Re: Submission to State Significant Development No. SSD7684

Site: 241-249 Wheat Road, Cockle Bay

Proposal / Proposed Development: Stage 1 Concept ('Built Form Envelope')

Submission on behalf of: Tianlong Ribbon Pty Ltd (Future Owners of 'The Ribbon Hotel' at 31 Wheat Road)

3D VIEW BUILDING ENVELOPE

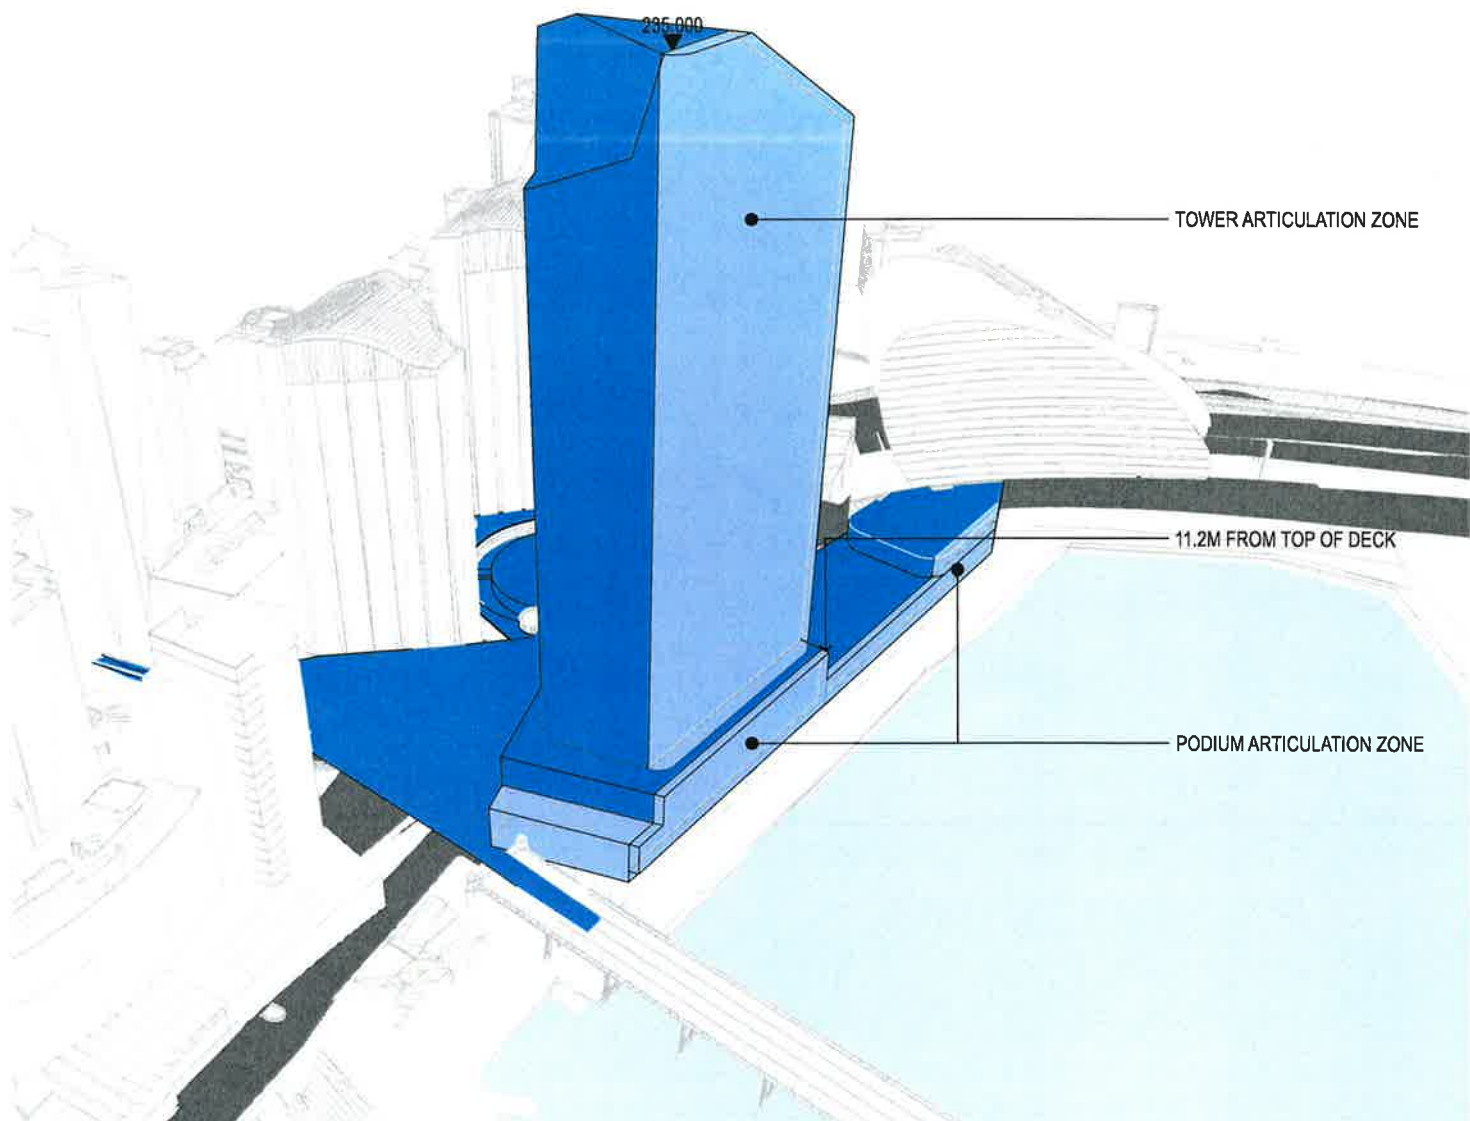
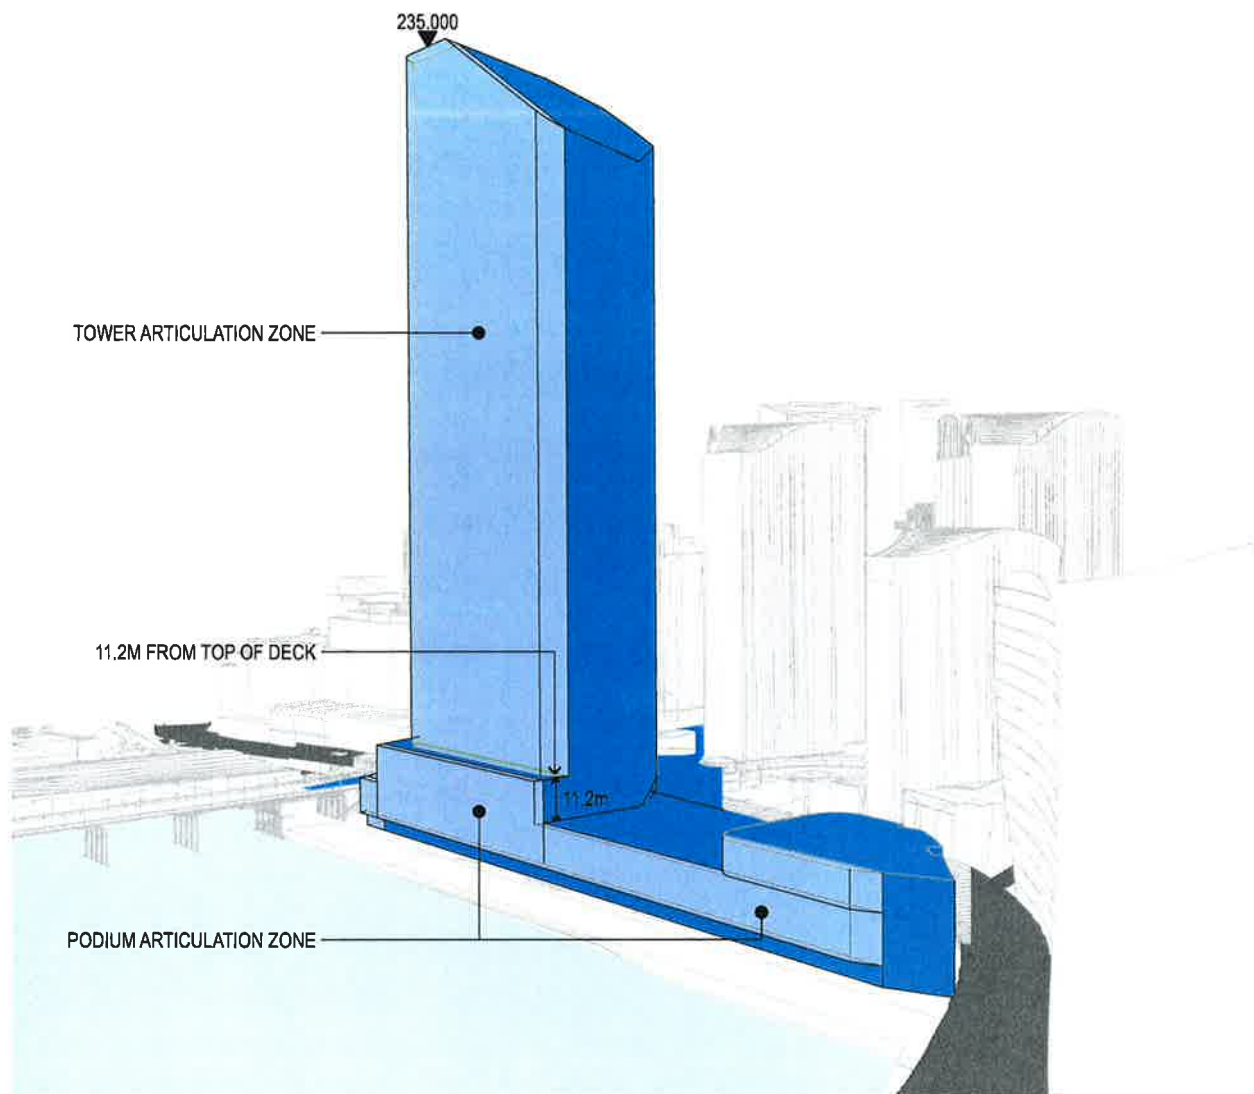
This submission is the Proposed Development, particularly the podium and tower building envelope (see Figure.1 below) is excessive for the following reasons (addressed in more detail in sections below):

- 2.1. The **Podium envelope** extends over vital public open space to the south of the existing Druitt Street pedestrian overbridge and is too close to the 'southern boundary' and adjacent development. This will impact on connectivity and views from Druitt Street/ Wheat Road through to Cockle Bay and The Ribbon Hotel and is an overdevelopment of public land in this location.
- 2.2. The **Southern Pavilion or Tower envelope** is located too close to the 'southern boundary' and adjacent development, blocks connections and sight-lines from Druitt Street to Cockle Bay, and it will overshadow the public domain of Cockle Bay waterfront and The Ribbon Hotel.

2.3. The **Northern Tower envelope** is excessive in that it is:

- a) located too close to the waterfront and impacts on the 'human scale' and amenity of the waterfront promenade / public domain;
- b) too high and the height is inconsistent with surrounding building heights and the CBD skyline, not suitable for this location on the Harbour, not required to create a 'gateway' development, and produces unacceptable impacts on the public domain and surrounding development;
- c) too bulky and of an excessive dimension to support the intended tower floor plates;
- d) inconsistent with the adopted planning policies and strategic direction for Cockle Bay and surrounding development, particularly relating to building heights in close proximity to the waterfront;
- e) has potential to create significant wind and shadow impacts on the public domain and adjacent buildings to the south.

- 14.1. Additional details should be provided for the envelope including justification for the 'site boundary', dimensions to adjacent properties, and more detailed and transparent impact analysis on adjacent development.

- 14.2. The podium should not extend further south than the centreline of the existing Druitt Street pedestrian overbridge and should achieve a minimum setback of 40m from The Ribbon Hotel at ground and all levels.
